Dáta | Date  
21 July, 2023

Ár dTag | Our Ref.  
TII22-118216

Re. **Strategic Infrastructure Development – Construction of Dyrick Hill Wind Farm comprising 12 wind turbines and related works, Co. Waterford (ABP Case ref. PA93.317265)**

Drawing file: 11. Planning Drawing Schedule and Planning Drawings / 05829-DR-169_Trench In National Road.pdf

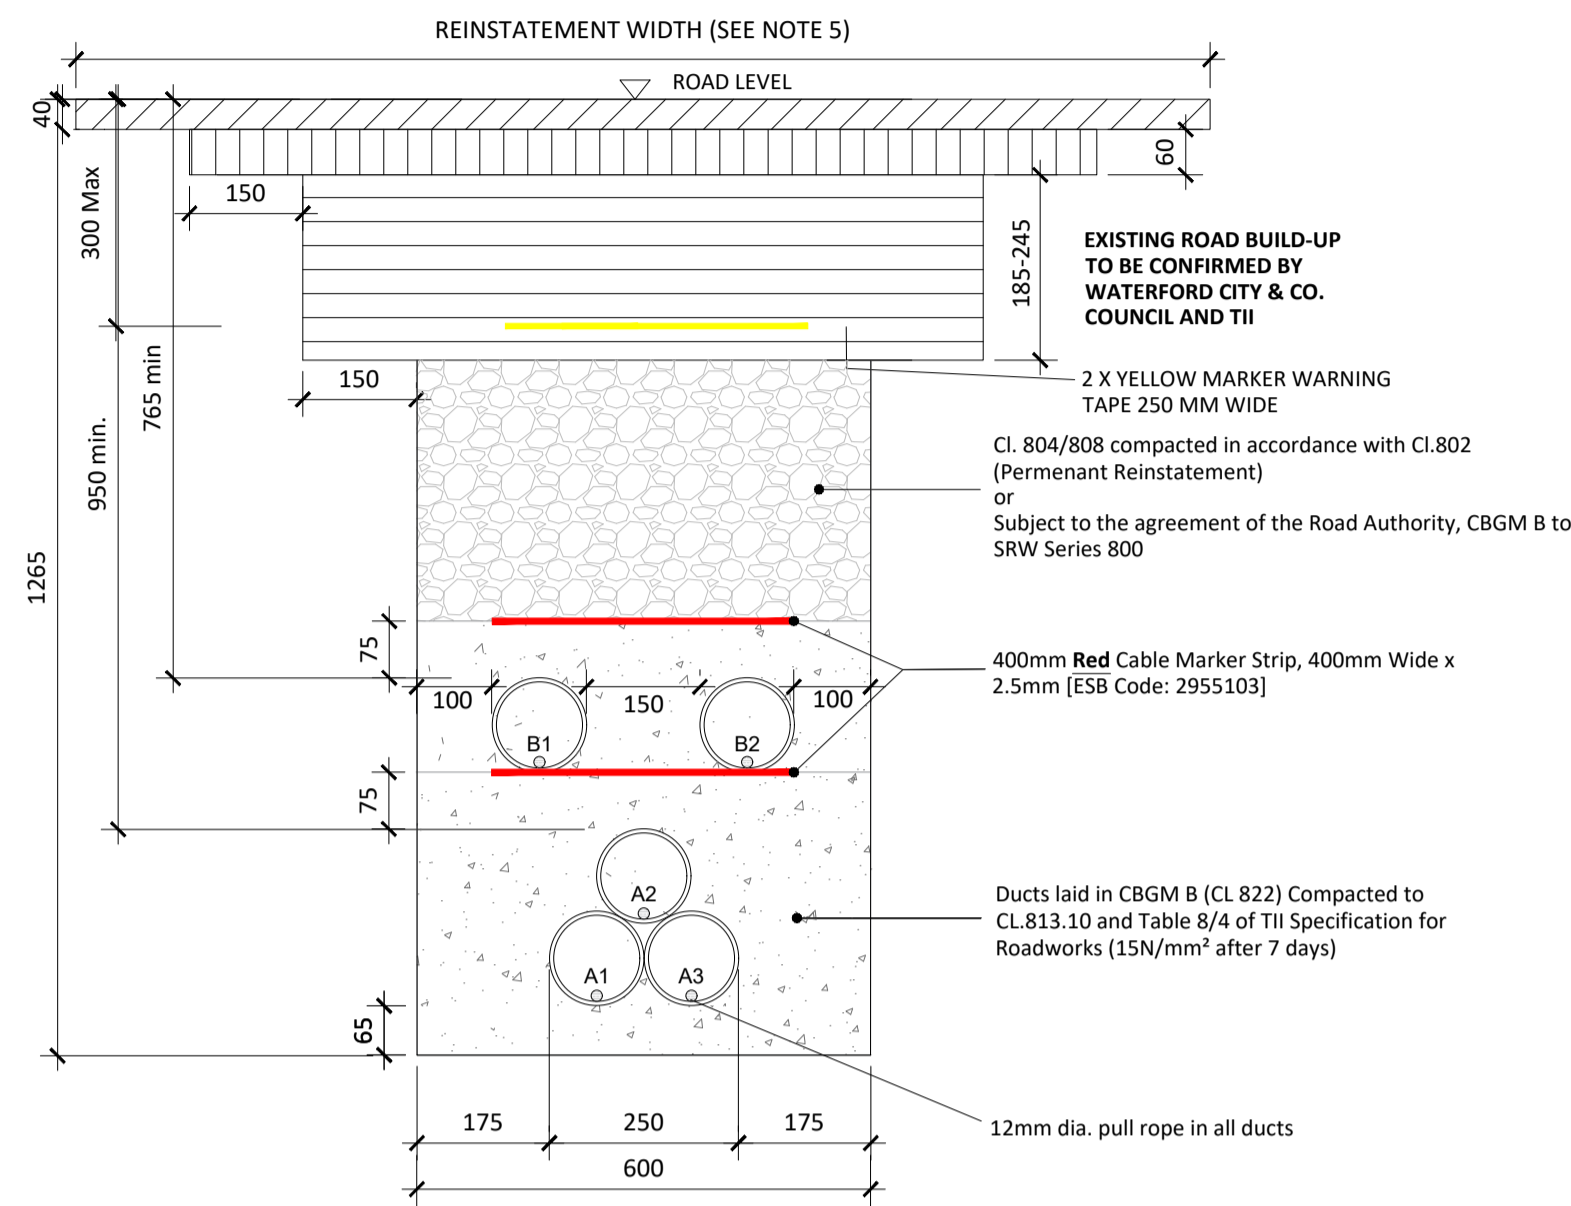
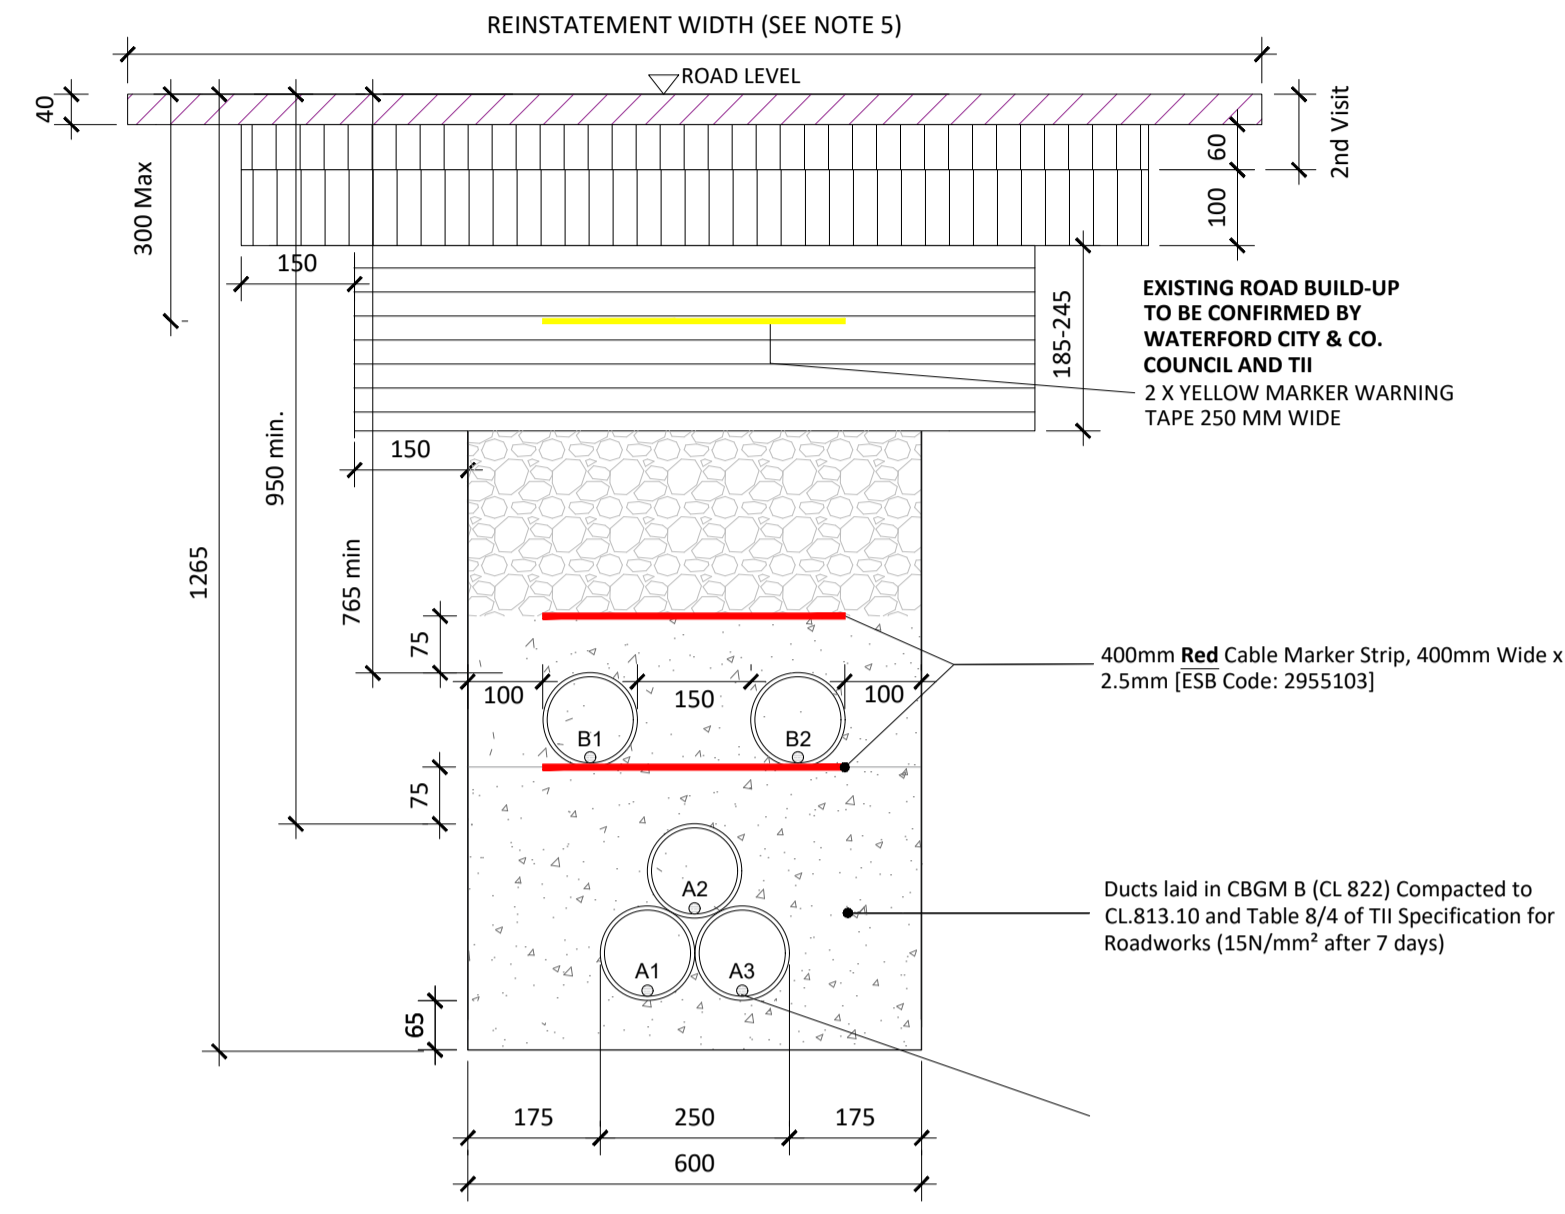
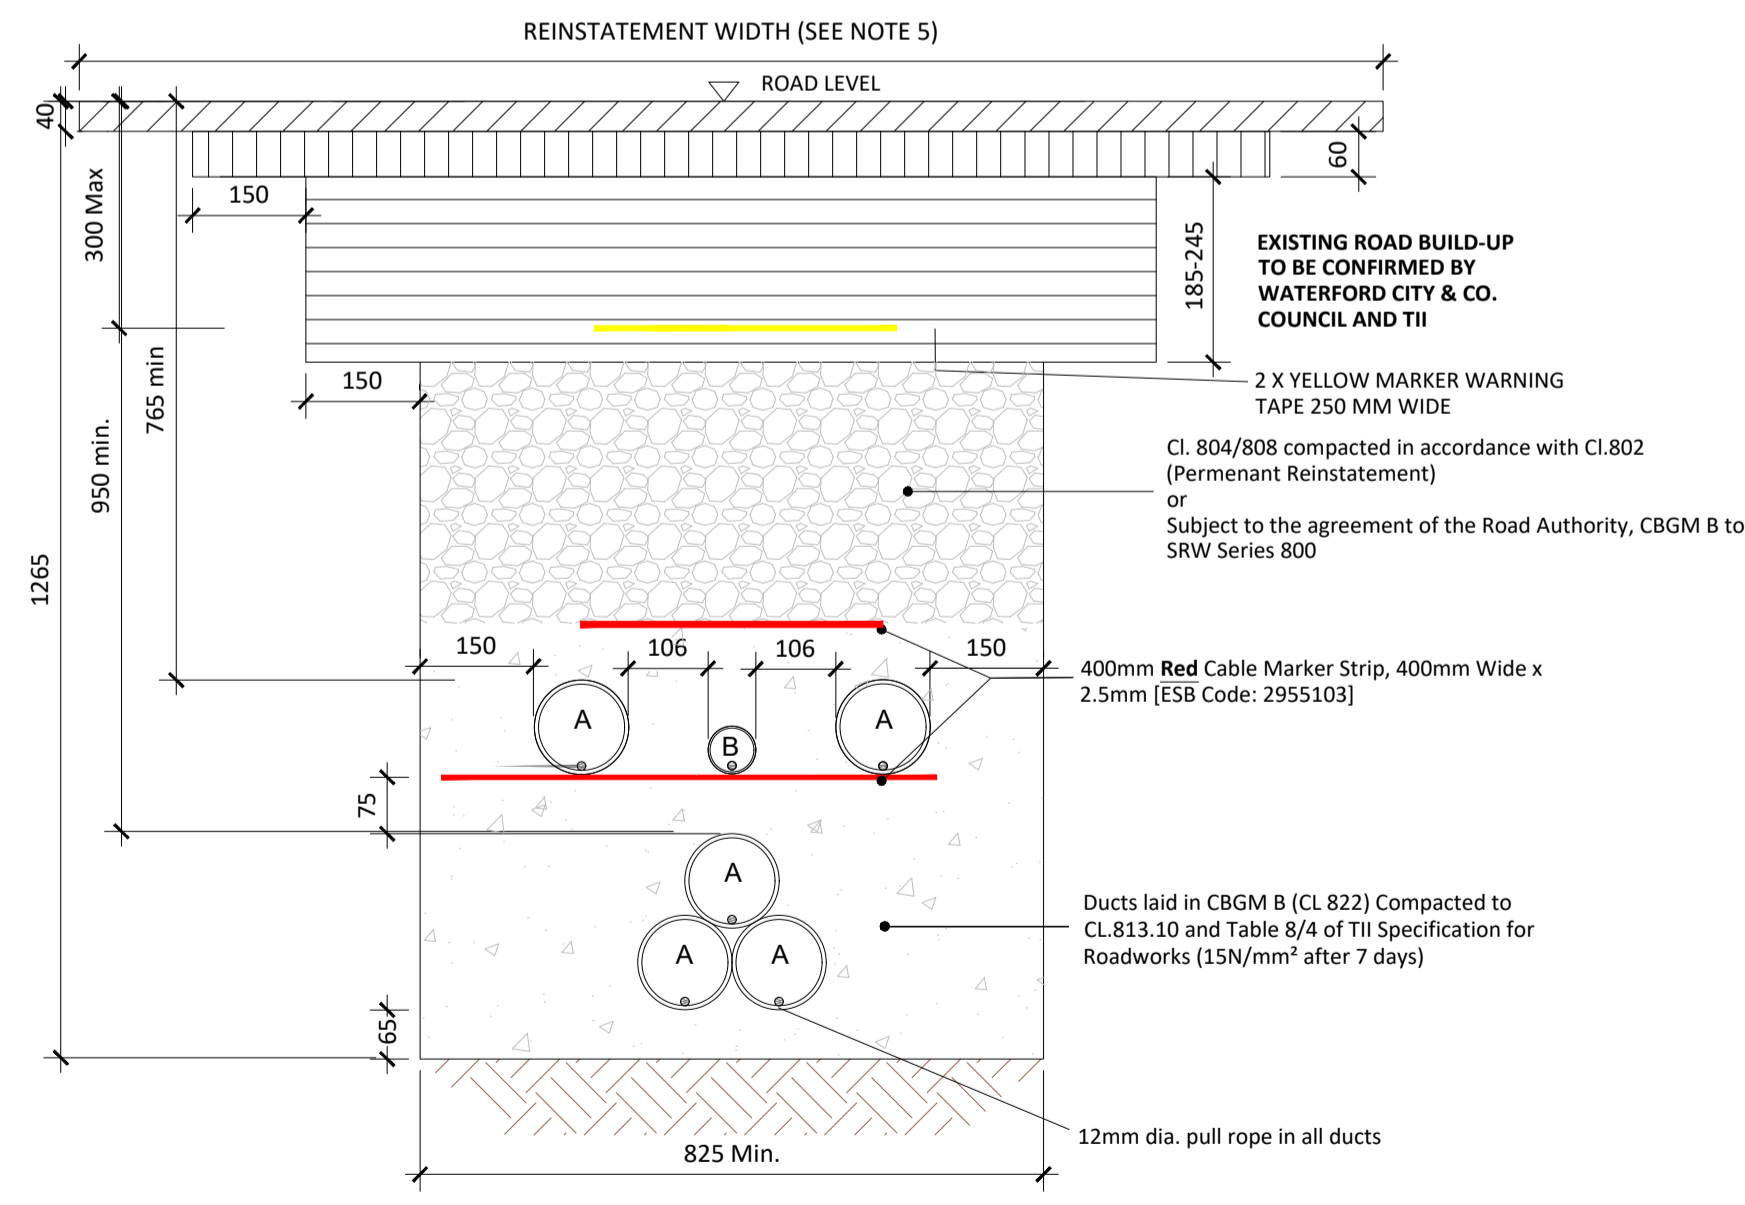
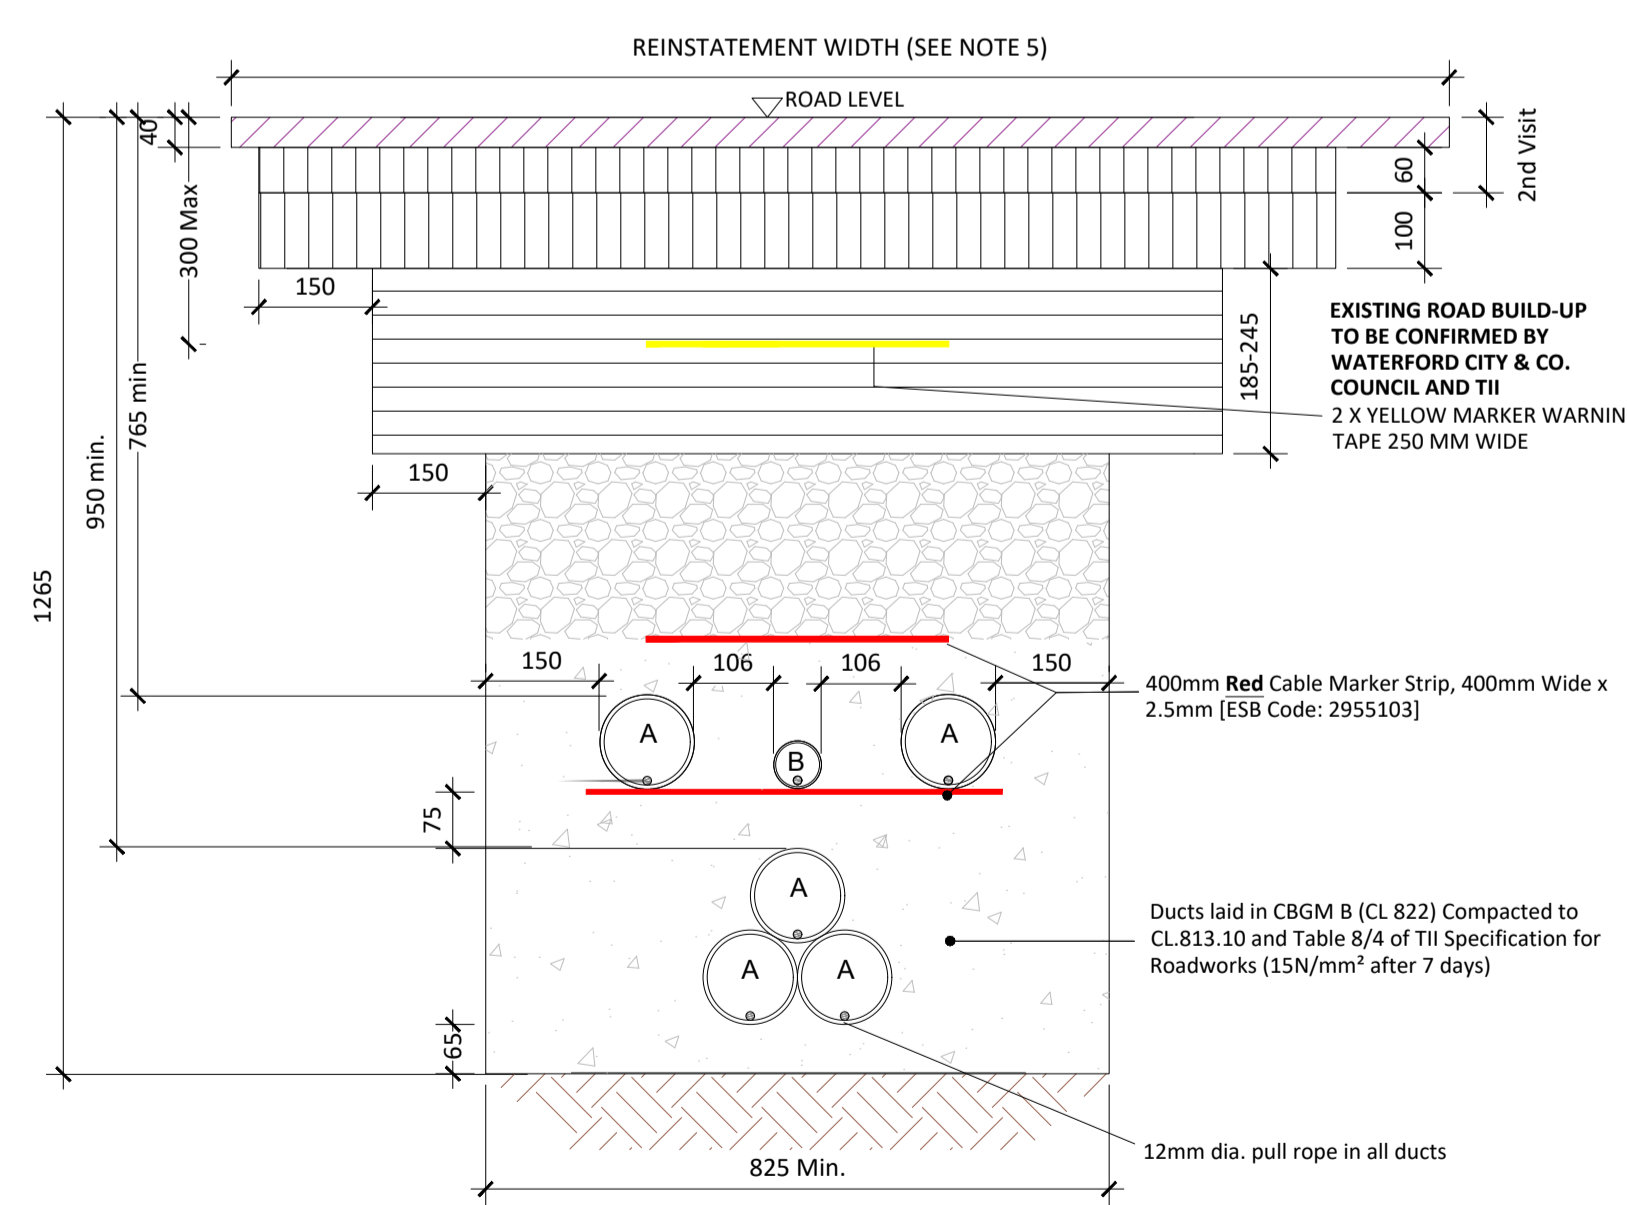
Section 2.2 of the EIAR outlines that the proposed development also includes proposals for the connection of the wind farm to the national electricity grid via a 110 kV underground cable connection approximately 16km in length to the existing Dungarvan 110 kV Substation; approx. 1.2km of the grid connection routing is proposed within the N72, national road.

Drawing Sheet No. 05829-DR-101 outlines the extent of works to the section of N72, national road, impacted, including the grid connection routing, Joint Bays 1 and 2 and a HDD crossing of the River Colligan in the vicinity of Kildangan Bridge which is a national road structure (TII Structure ID: WC-N72-007.00). TII has not agreed nor consented to any works in the national road.

TII has identified a number of significant implications for TII and road authorities in the management and maintenance of the strategic national road network resulting from the laying of high voltage electricity cabling in the national road reservation, including;

- Impacts on embankments, bridges, drainage and road furniture infrastructure leading to future maintenance liabilities,
- Impediments to future maintenance and operations activities, such as safety barrier repair and French drain renewal,
- Impediments to future routine network improvements such as pavement overlay and strengthening, installation of new verge-side signs and other road furniture,
- Impacts on network traffic flows during installation,
- Impediment to future on-line upgrades of national roads because of the implications to road authority / TII in having to incur the additional costs of moving underground cables in order to accommodate the road improvements.

Proposals to lay cable in the national road reservation, including the construction of associated joint bays, such as that outlined in the subject application, have the potential to impact road authorities and TII in undertaking future maintenance and improvement requirements. There may also be additional cost implications to national road improvements and maintenance resulting from the presence of high voltage cabling within the national road reservation.

In addition to the foregoing, it does not appear that the impact on traffic flows, delays, etc. of necessary traffic management measures to facilitate construction in the N72, national road, has been considered in any detail in the EIAR.

In the interests of safeguarding the investment in and the potential for future upgrade works to the national road network, the Authority is of the opinion that the Proposed Grid Connection Cable Routing fails to address important policy considerations impacting national roads.

There is a critical requirement to ensure the strategic capacity and safety of the national road network is maintained and significant Government investment already made in the national road network is safeguarded. TII is of the opinion that the proposed grid connection cable routing does not reflect the foregoing provisions of official policy and recommends that an alternative grid connection proposal is prepared.
